STATE OF NORTH CAROLINA
DEPARTMENT OF TRANSPORTATION

Addendum No. 2

RE: Contract # C204359

US-70 FROM US-70 BUS TO NEUSE RIVER BRIDGE WITH INTERCHANGES
AT SR-1501 (SWIFT CREEK RD) AND SR-1919 (WILSONS MILLS RD).

PROJECT REFERENCE NO.	W-5600	SHEET NO.	UC-22B
DESIGNED BY:	SS	DATE:	3/3/2021
DRAWN BY:	SS		
CHECKED BY:	MVZ		
APPROVED BY:	MVZ		
REVISED:			
NORTH CAROLINA DEPARTMENT OF TRANSPORTATION			
UTILITIES ENGINEERING SEC. PHONE: (919) 707-6690 FAX: (919) 250-4151

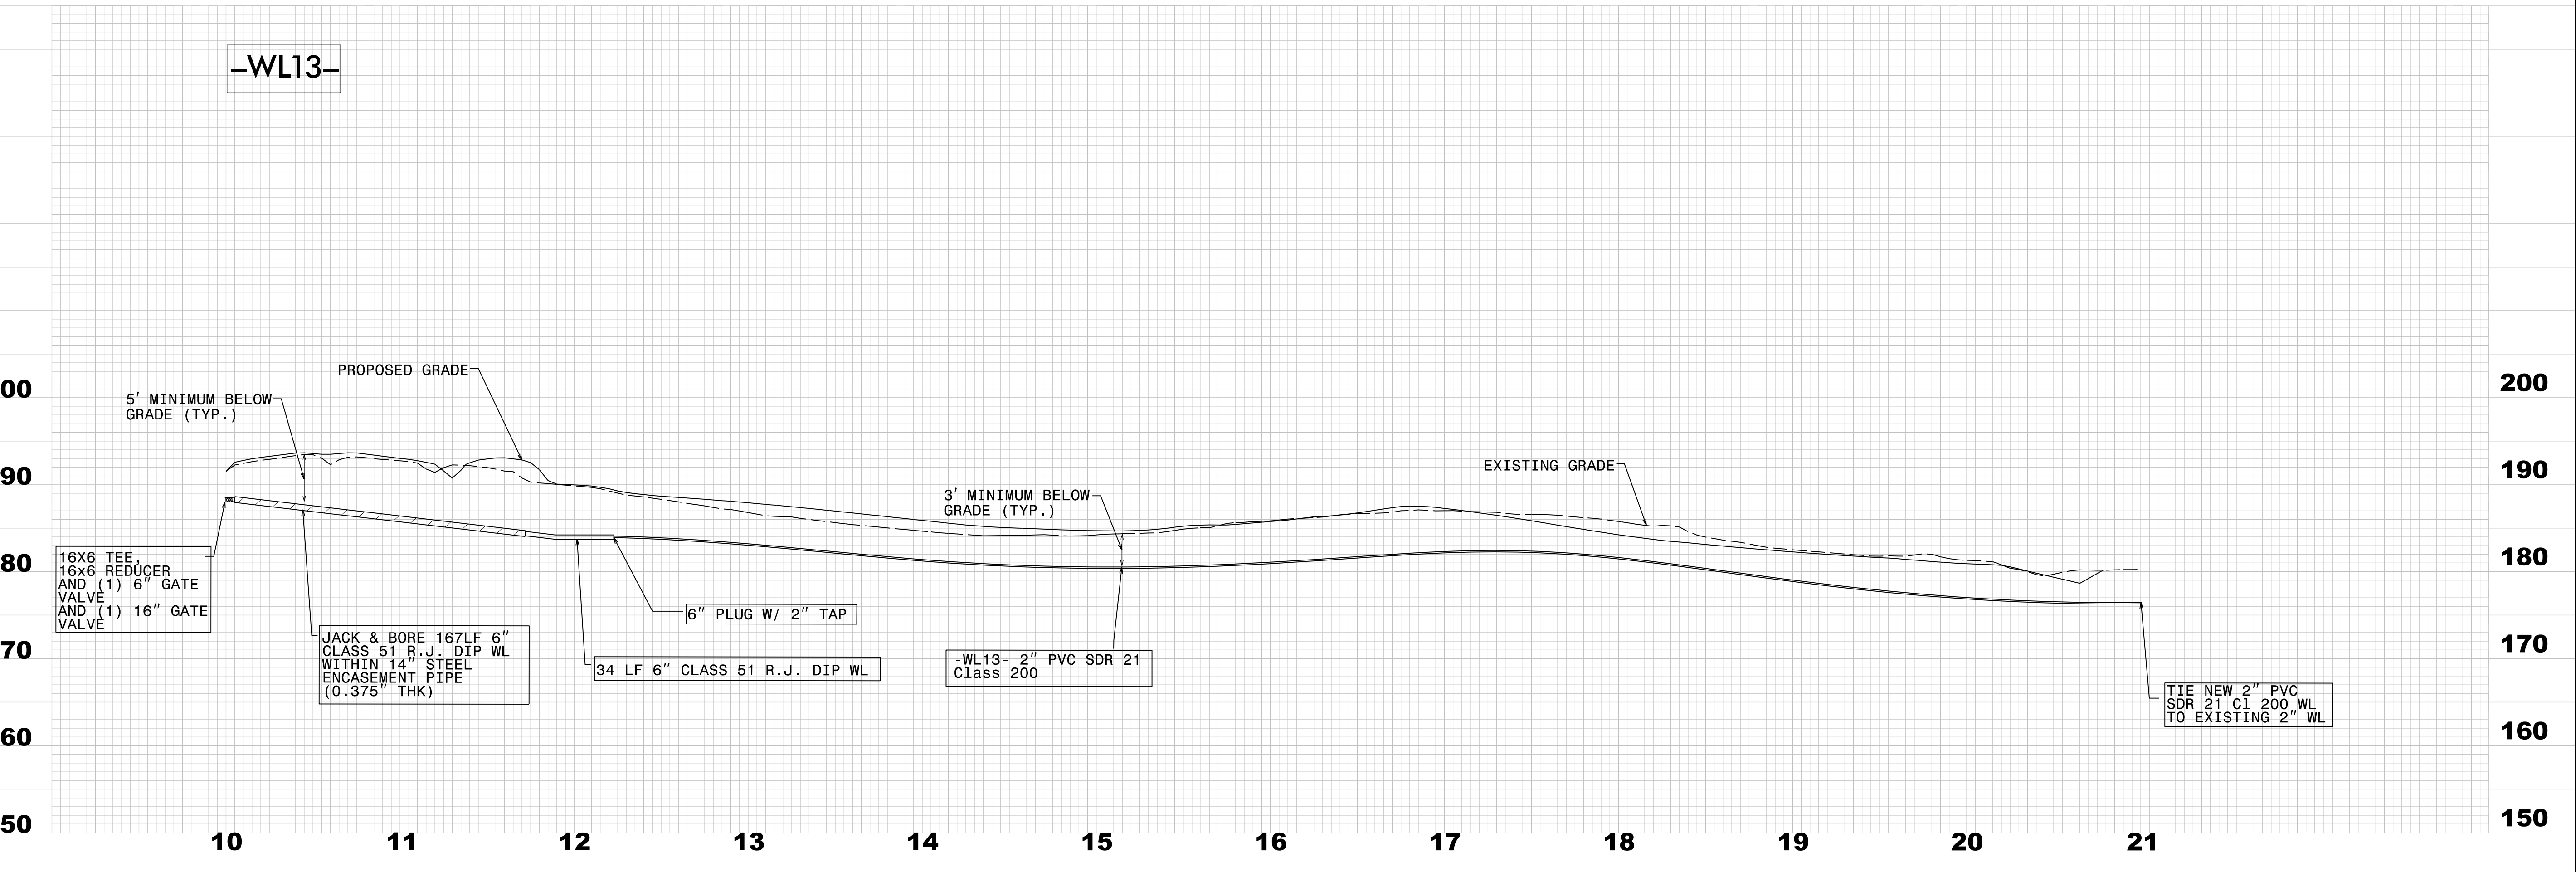
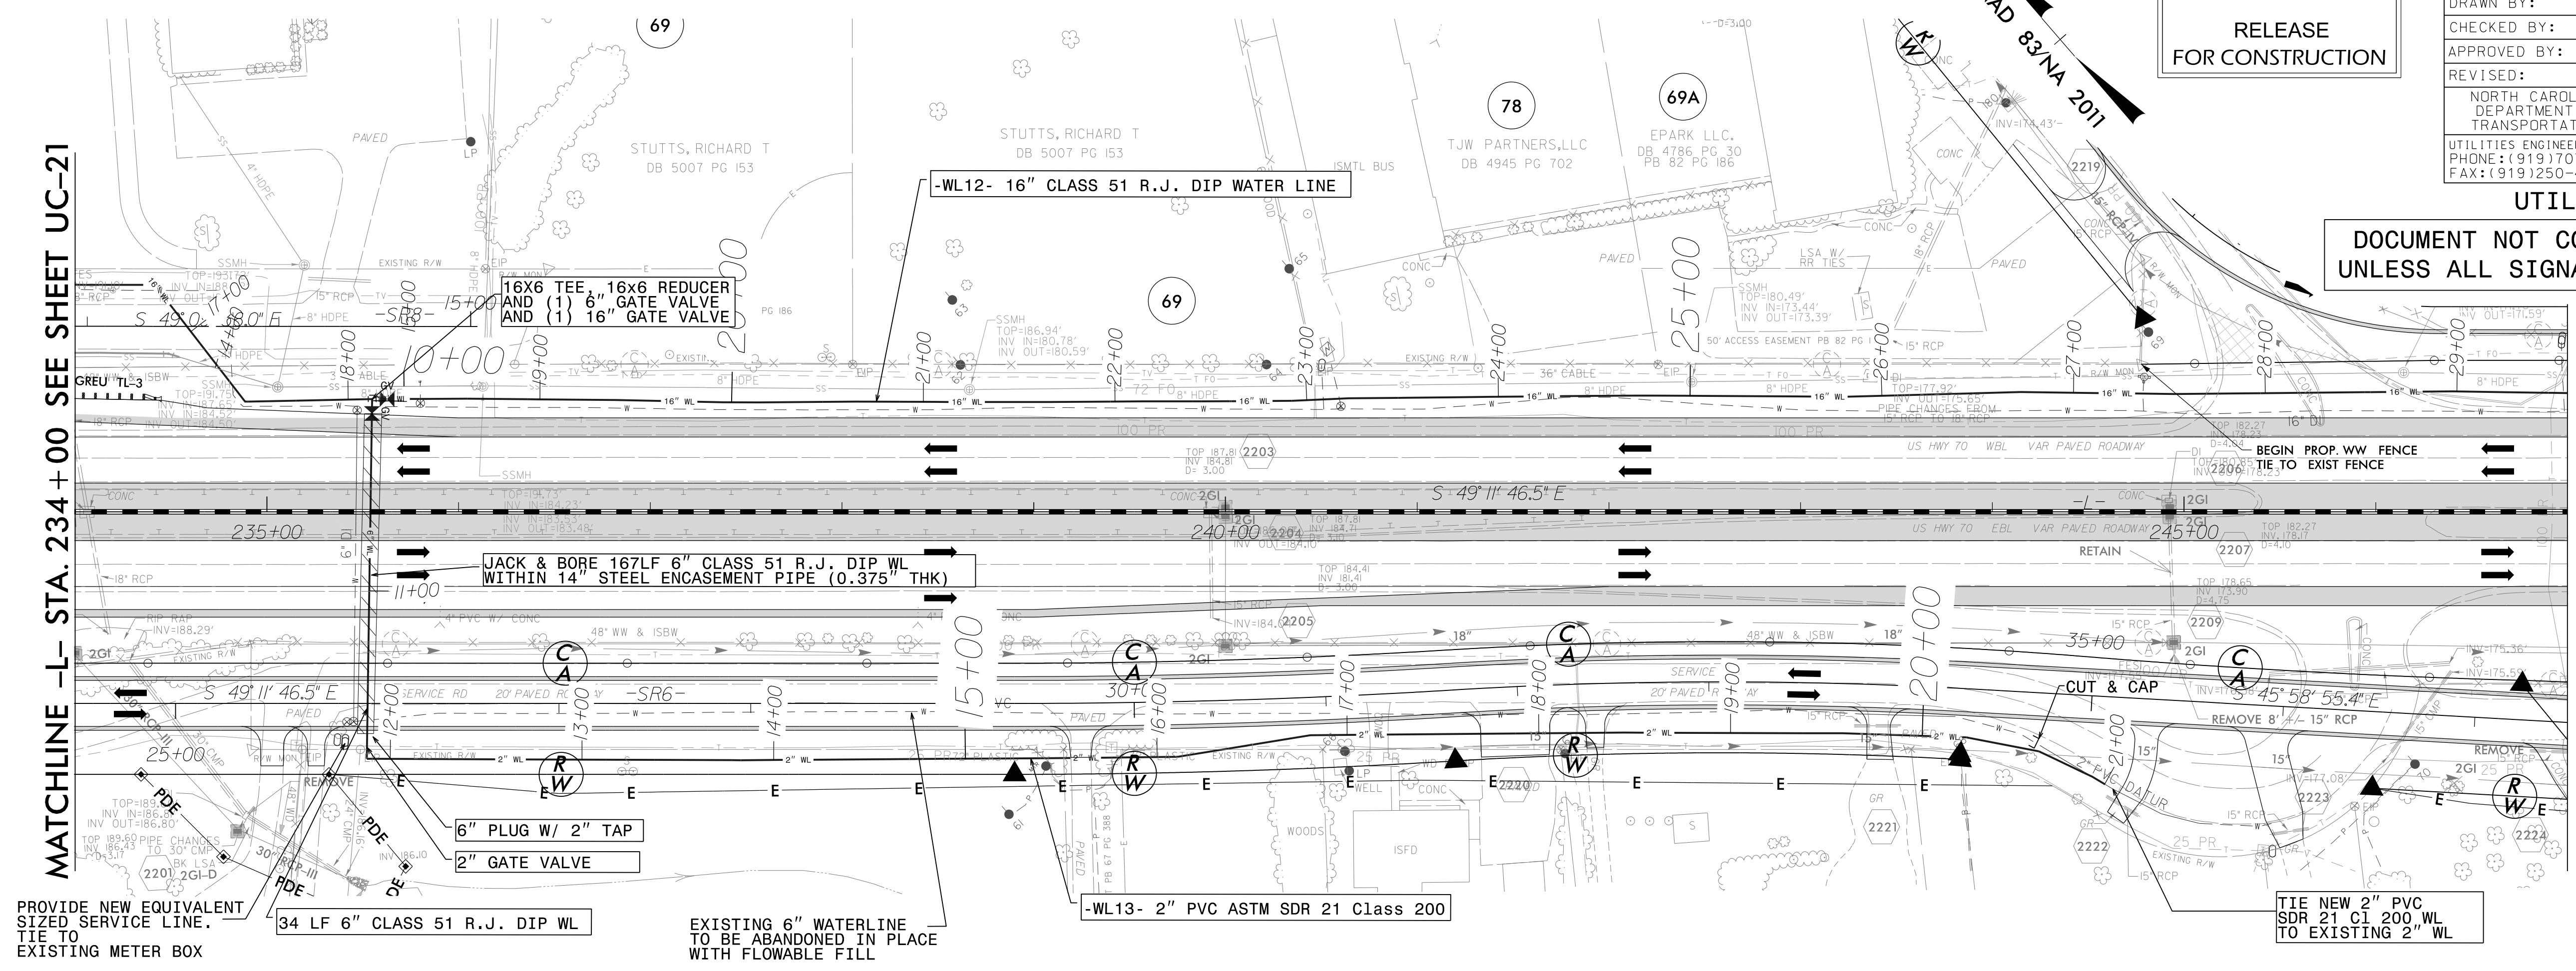
Sheet No.	Revision
UC-16B	-WL 9A- casing length revised to 27 LF. -FSS 3- casing length revised to 37 LF in plan and profile
UC- 22B	Revised casing length to 167 LF in plan and profile
UC- 25A	Adjusted the location of the proposed 12" branch line tie at the 16" line. Added a 16"x 12" Tee, 16" gate valve and 12" gate valve to plan and profile. Removed the 40' dimension note and revised the abandon and cut and cap notes
UC- 25B	Added note in for the tie ins of -WL 16- proposed 12" line. Referenced the updated 12" branch line with tee and valves
